Approval of details reserved by condition imposed under ref BN/50/20/PL relating to Condition Nos 5 - mitigation method statement, 6 - archaeology, 7 - piling risk assessment & method statement, 8 - Construction & Environmental Management Plan, 9 - foul drainage, 10 - surface water drainage, 11 - maintenance & management of surface water drainage, 13 - pre-commencement site meeting, 15 - odour assessment or evidence that livery has ceased, 16 - soil resource plan, 17 - landscaping, 18 - screen walls & fences, 19 - elevation details of 2 proposed communal bin stores and 20 - colour schedule of materials & finishes.

Land Rear Of 1 Northfields Cottages Fontwell Avenue Eastergate PO20 3RX

Condition Number 13

Arun District Council have decided to **REFUSE details reserved by condition for the following reasons:**

LLD1544-ARB-DWG-002

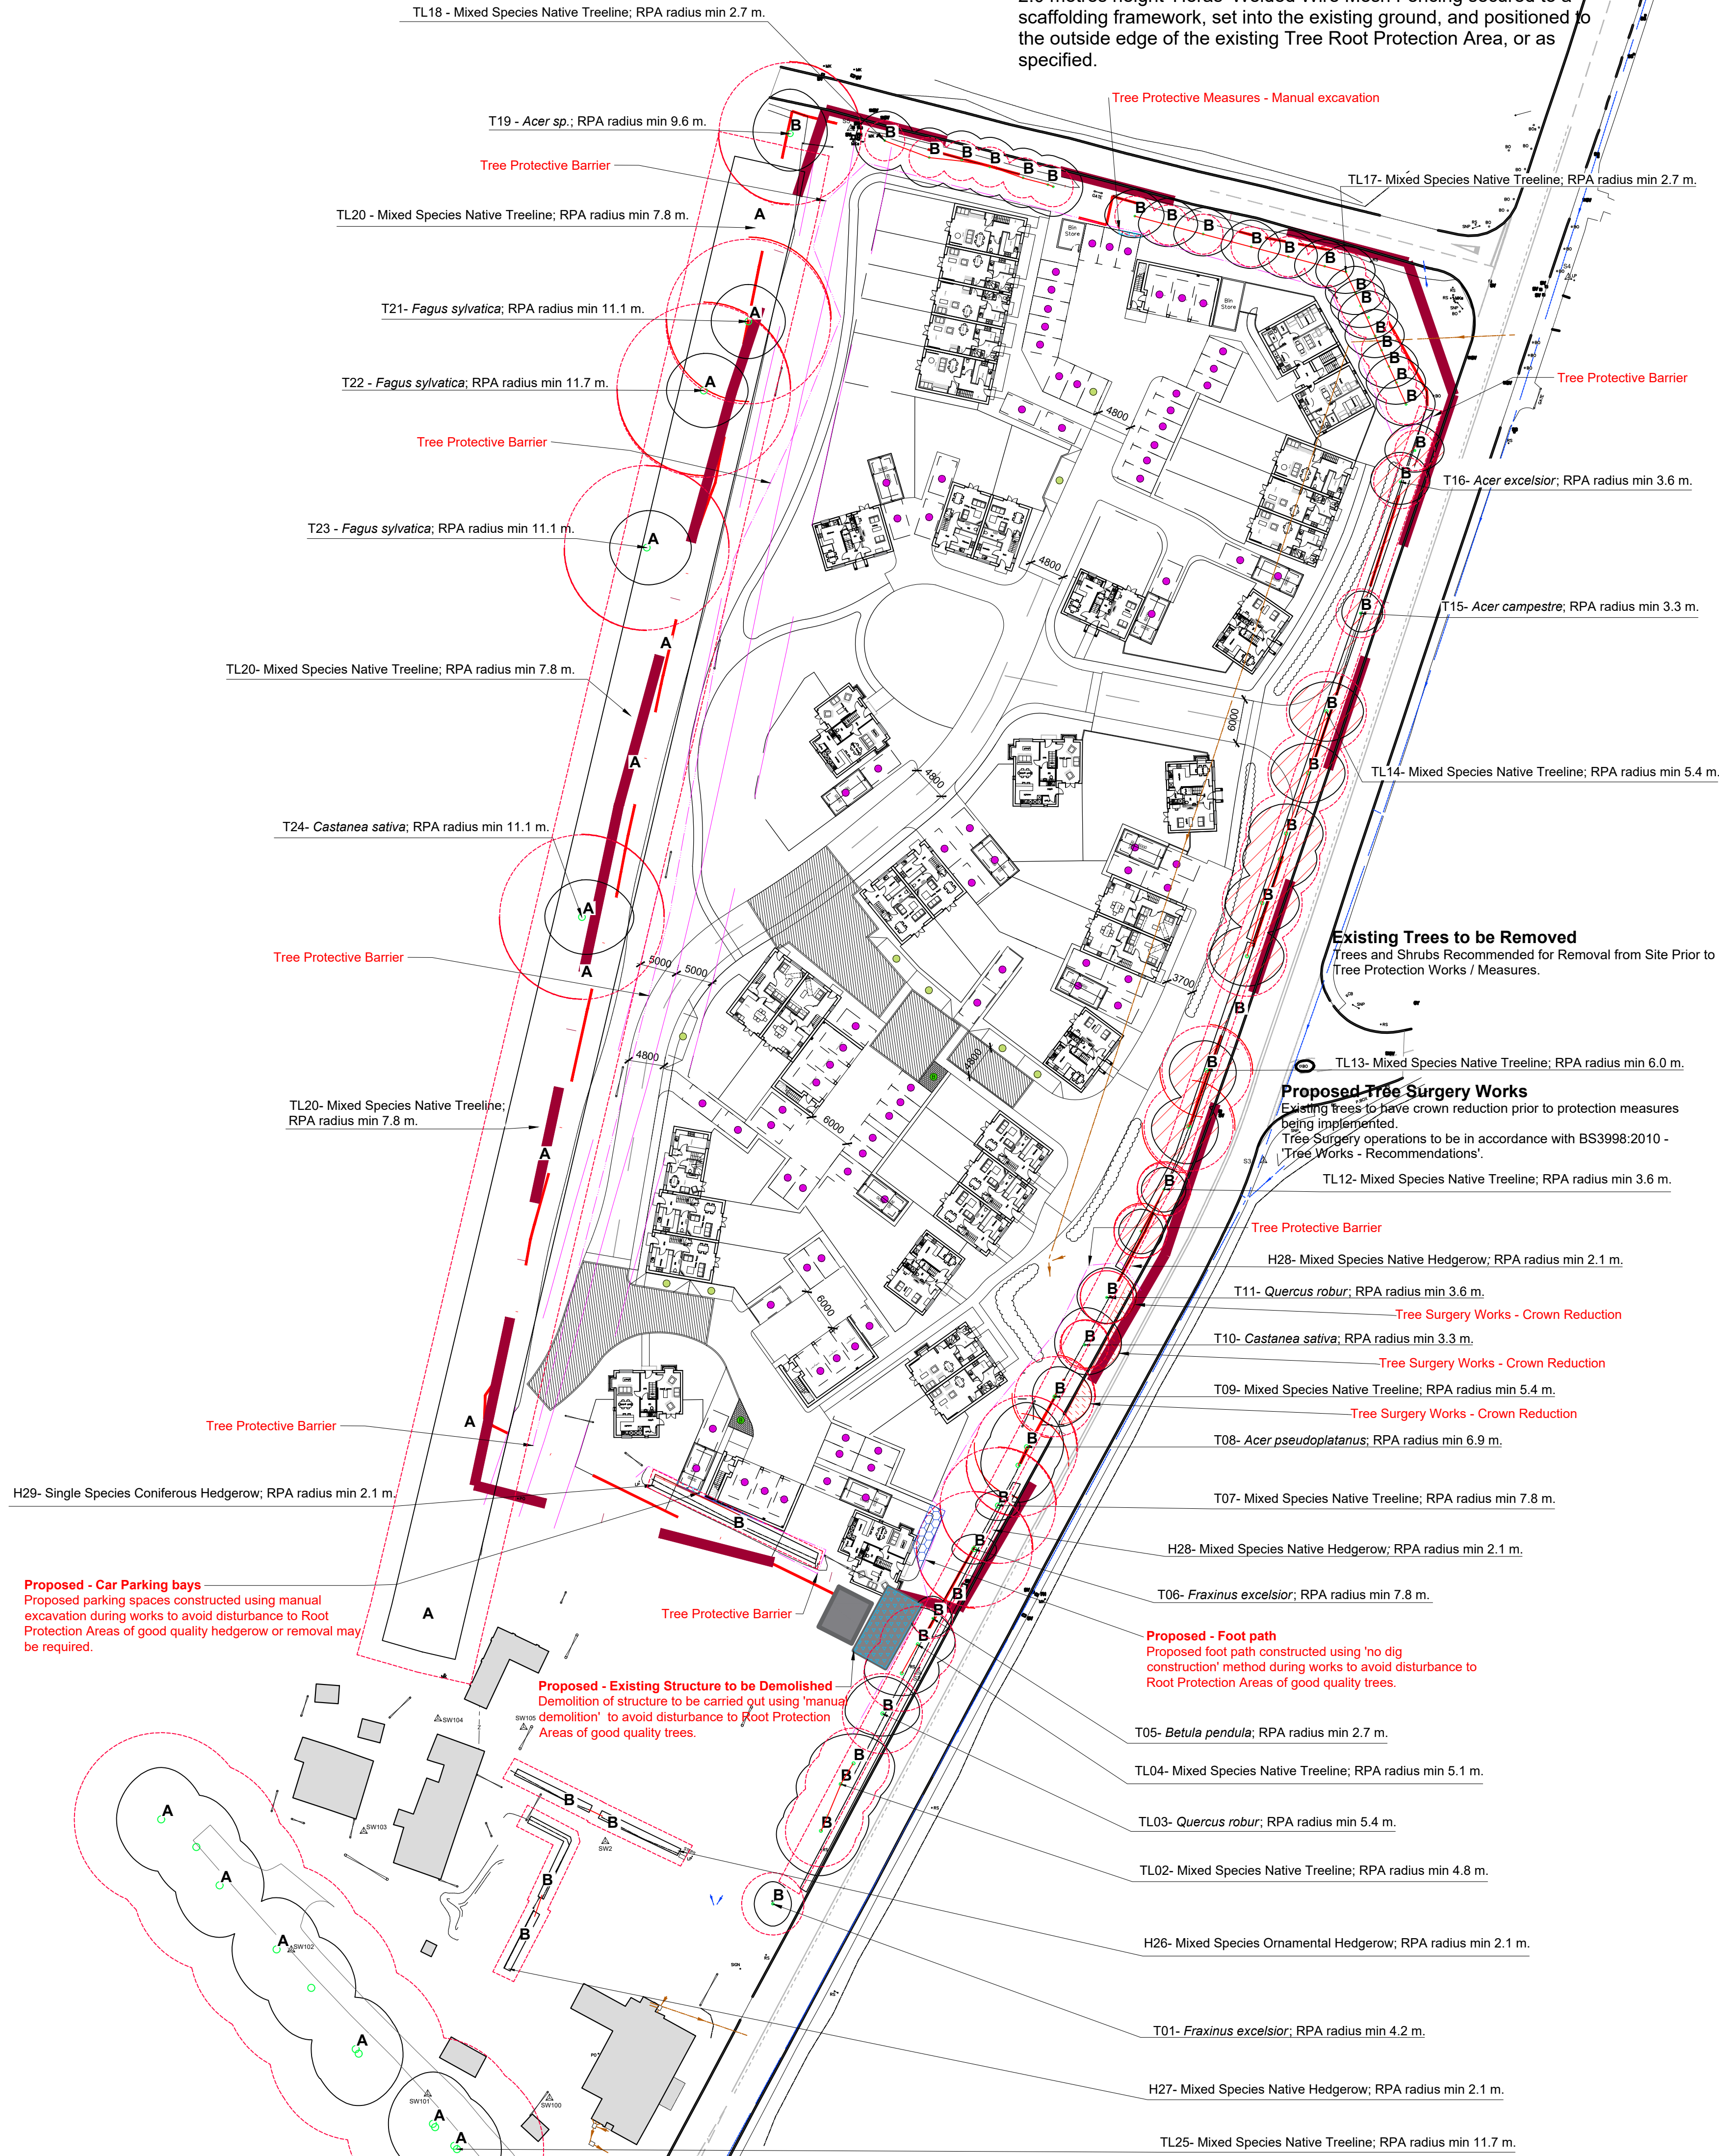
The Councils Tree Officer visited the site on 11/05/21 and as per his email to you on 13/05/21, he reported a number of issues with the tree protection scheme that had been implemented:

- Fence line is open at NW corner of site.
- Fence line is open at existing 5-bar gated access from Fontwell Avenue.
- All weather notices attached to HERAS panels are scarce and their message lacks authority, appearing more to be an advertisement for the tree work contractor who provided them. The following important wording is missing: "Construction Exclusion Zone - NO ACCESS".
- There are no day-glo ribbons attached to the top of the barrier, to ensure the fencing is clearly visible during the works.

The Tree Officer requested that you confirm in writing and provide photographic evidence, as soon as those refinements have been made. No response has been provided and therefore the condition cannot be discharged at the current time and you will need to make a resubmission.
